**CITY OF ALBUQUERQUE
PLANNING DEPARTMENT
May 15, 2013
DRB Comments**

PROJECT # 1009692

APPLICATION # 13-70536

RE: Tracts 223 & 224, Town of Atrisco Grant

Exhibit for
Tract 223-A
Allotted Airport Unit
From Town of Atrisco
 Being Comprised of
 Portions of Tracts 223 and 224
 Airport Unit
 The Town of Atrisco
 City of Albuquerque
 Bernalillo County, New Mexico
 September 2013

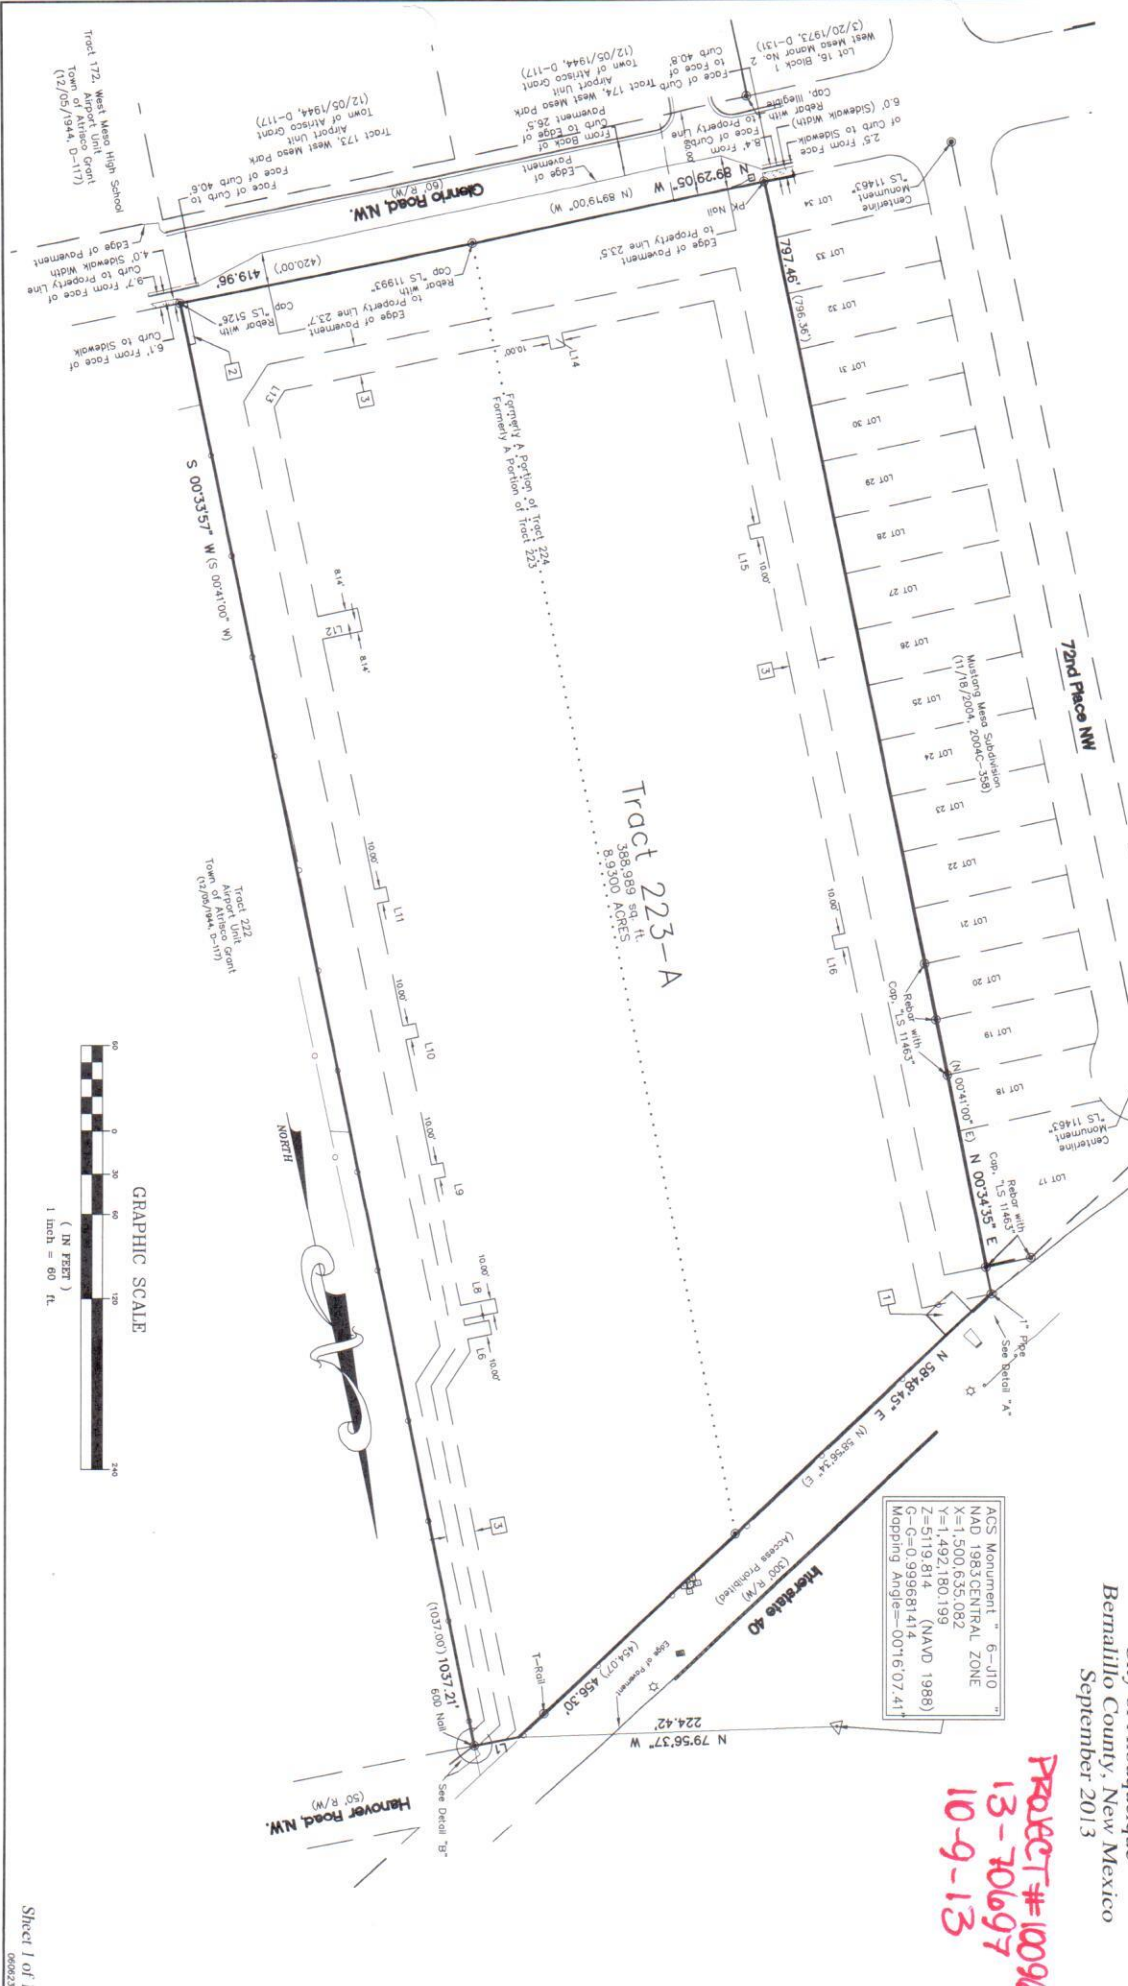
'Adjoiners' to the east do not match AGIS; there appears to be an opportunity for vacation of right of way for the small notch at Hanover.
